# Byers Gill Solar EN010139

## 3.3 DCO Schedule of Changes

Deadline 8 – January 2025

Revision 7

Drawing Title
Street Works, Public Rights of Way & Access Plans
Sheet 3 of 13
APFP Regulation 5(2)(k)

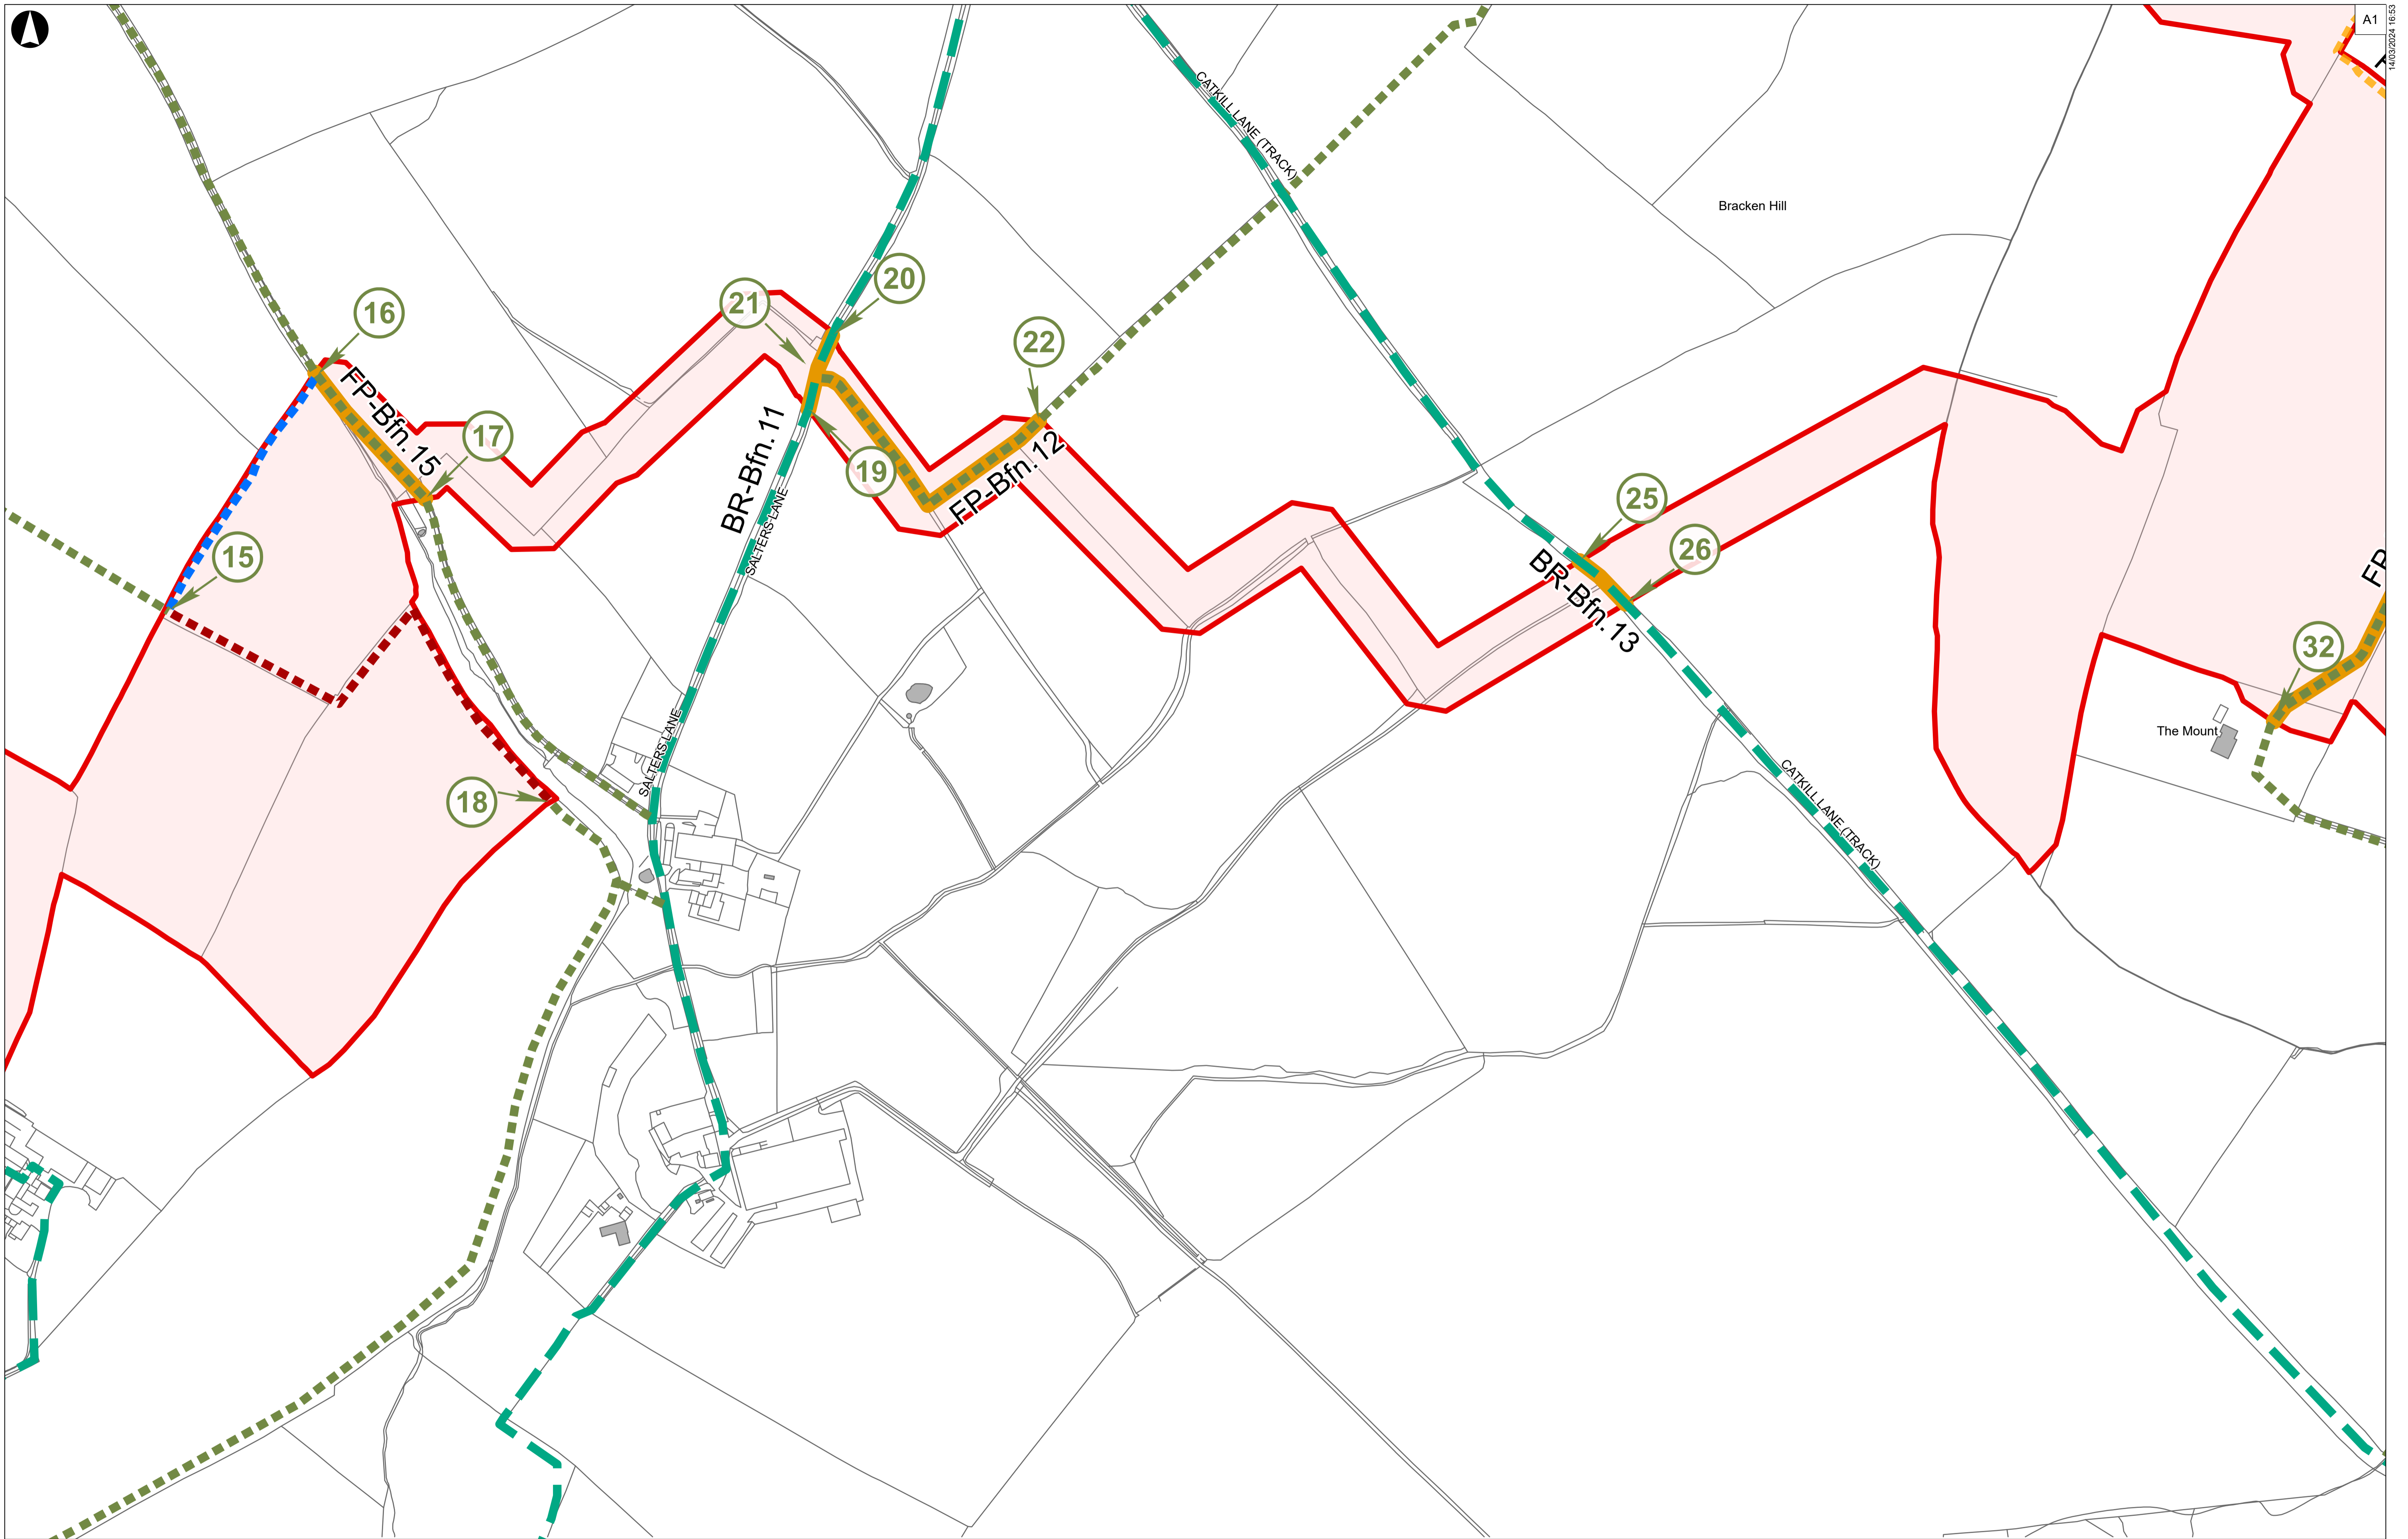
Parish of Brafferton	Unnamed Road	Cable works beneath the width of <del>highway</del> <u>street</u> comprising a length of 320m as shown between points marked A and B on sheet 3 of the street works, public rights of way and access plans.
-------------------------	-----------------	---

Drawing Title
Street Works, Public Rights of Way & Access Plans
 Sheet 9 of 13
APFP Regulation 5(2)(k)

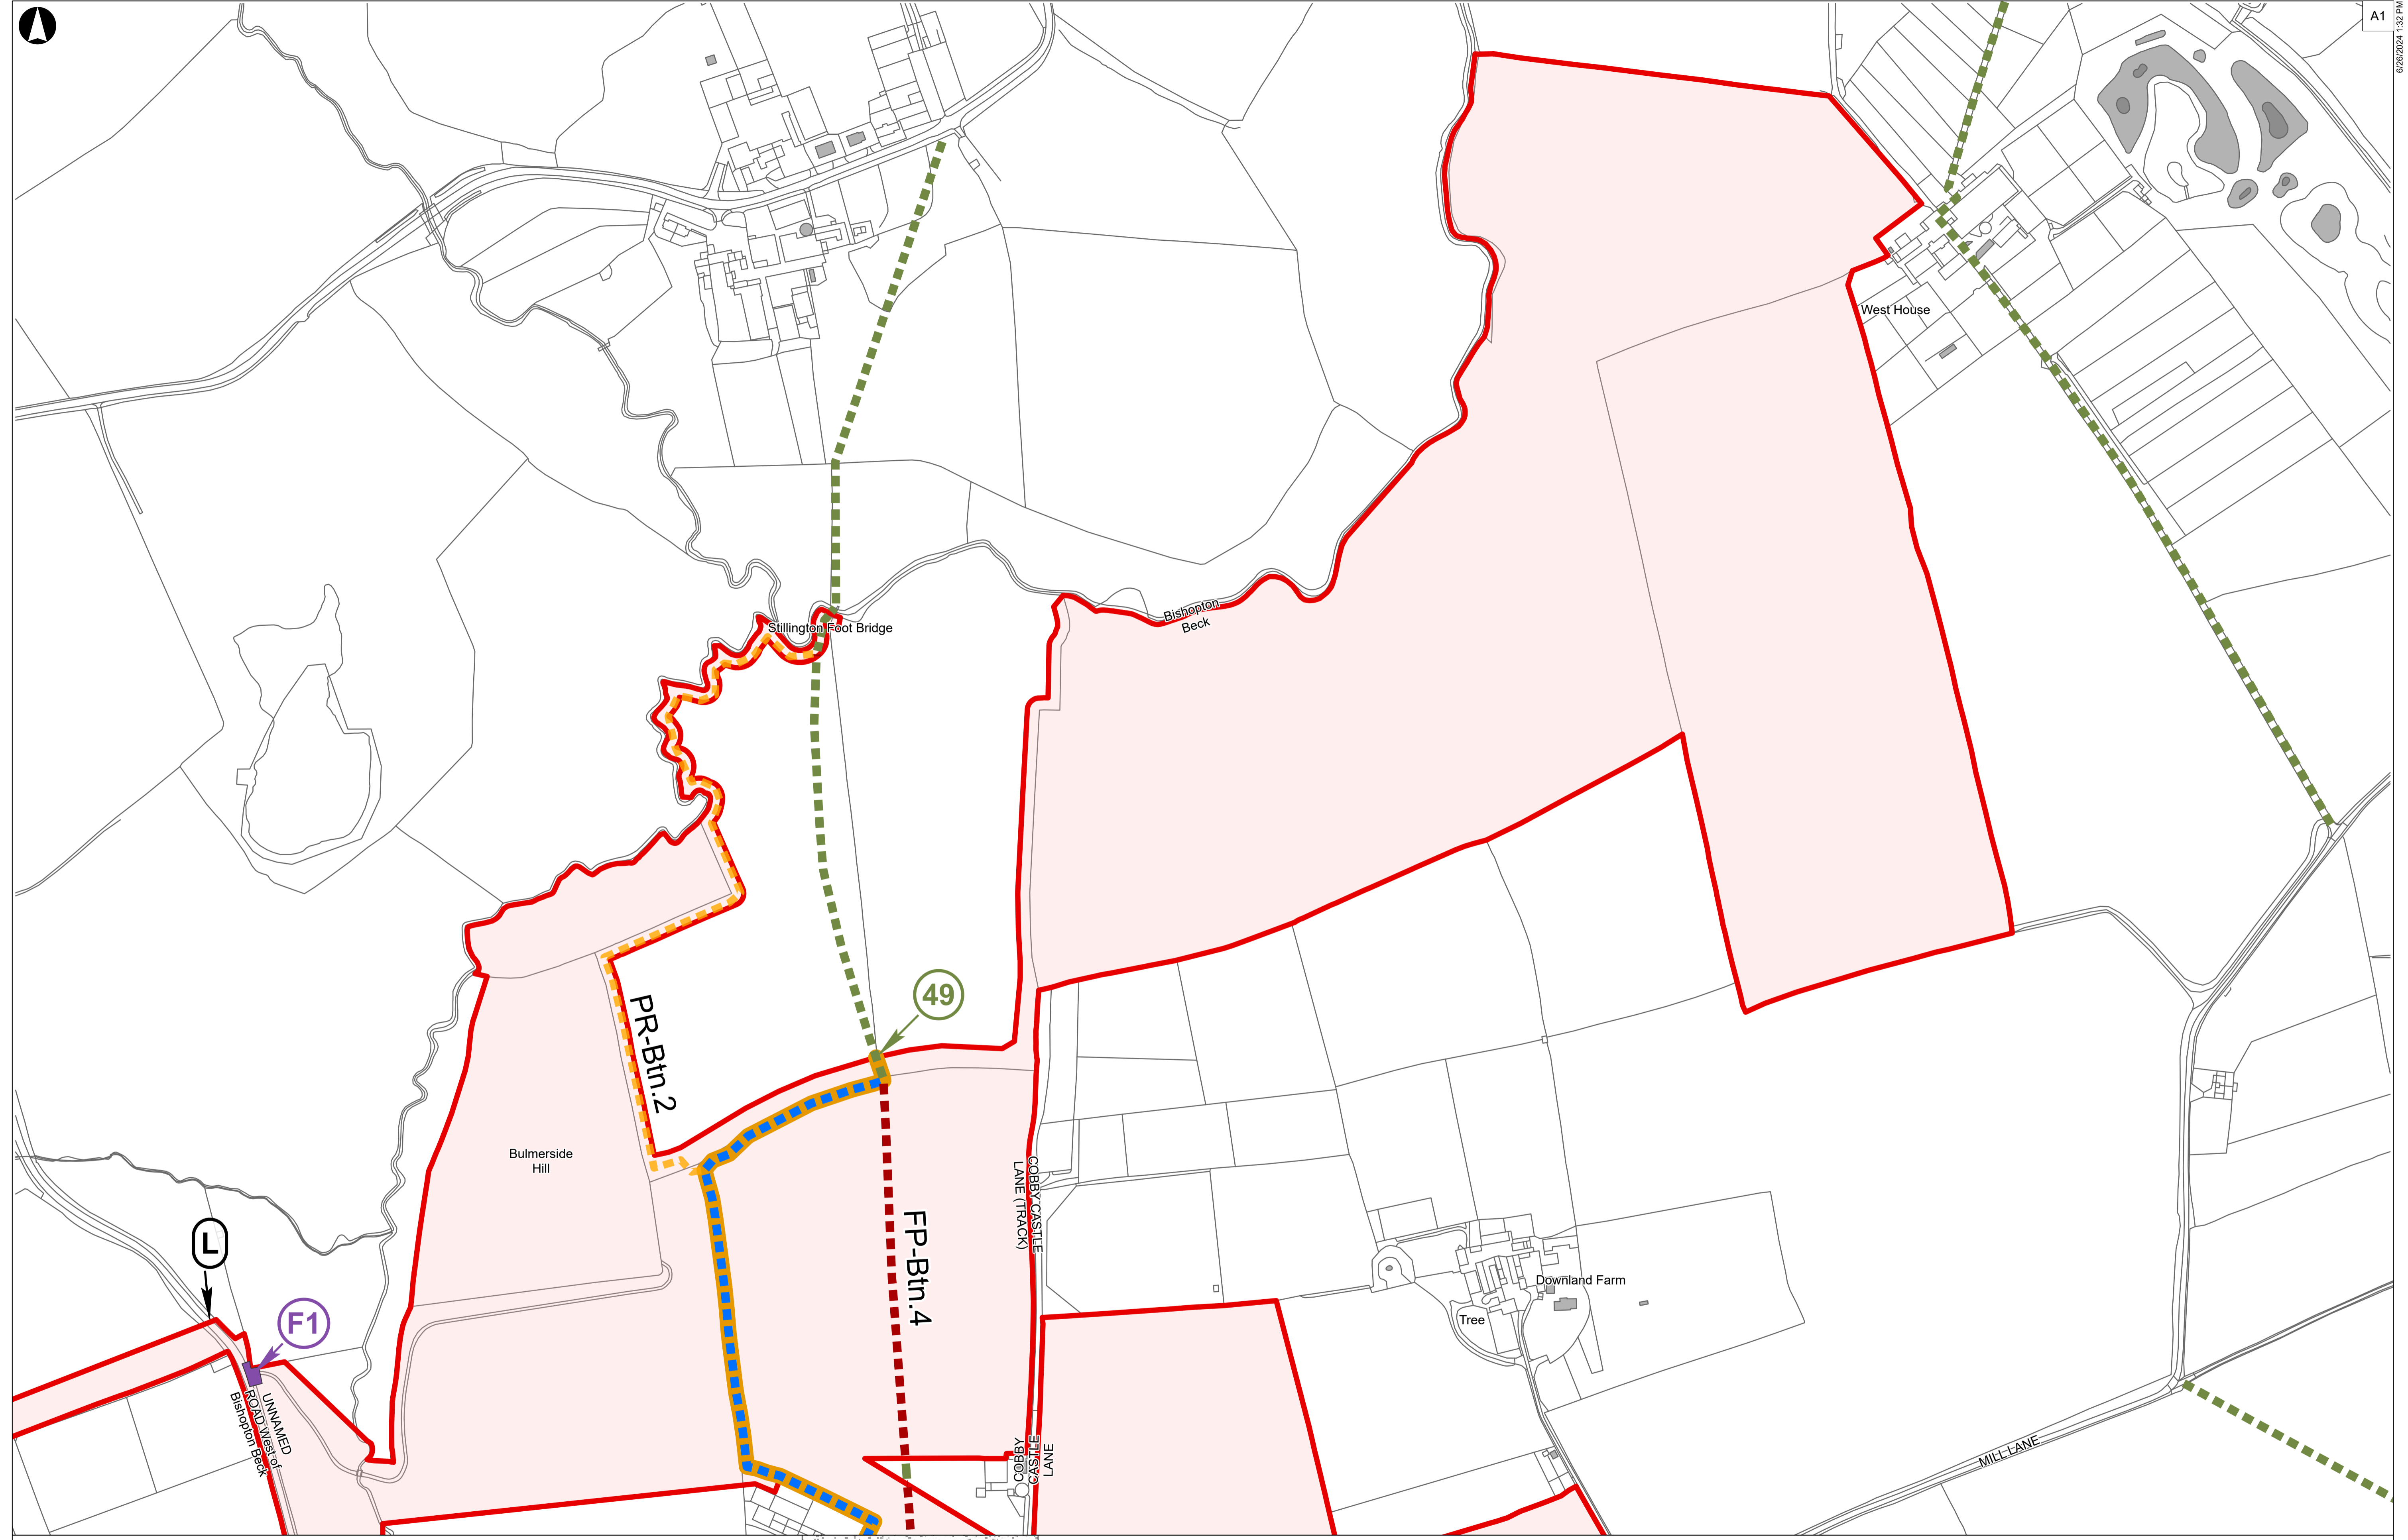
<u>Parish of Bishopton</u>	<u>Folly Bank</u>	<u>Cable works beneath the width of street as shown with reference CC5 on sheet 9 of the street works, public rights of way and access plans.</u>
<u>Parish of Redmarshall</u>	<u>Redmarshall Road, in the vicinity of Morrington Bridge</u>	<u>Cable works beneath the width of street as shown with reference CC6 on sheet 11 of the street works, public rights of way and access plans.</u>

These two rows have been added to provide street works descriptions for two locations where the Applicant proposes to carry out cabling works across the width of a street for the purpose of delivering the off-road cable route. These descriptions are included as a correction to Revision 1 of the dDCO.

Corresponding amendments have been made to the Street Works, Public Rights of Way and Access Plans to indicate these locations.
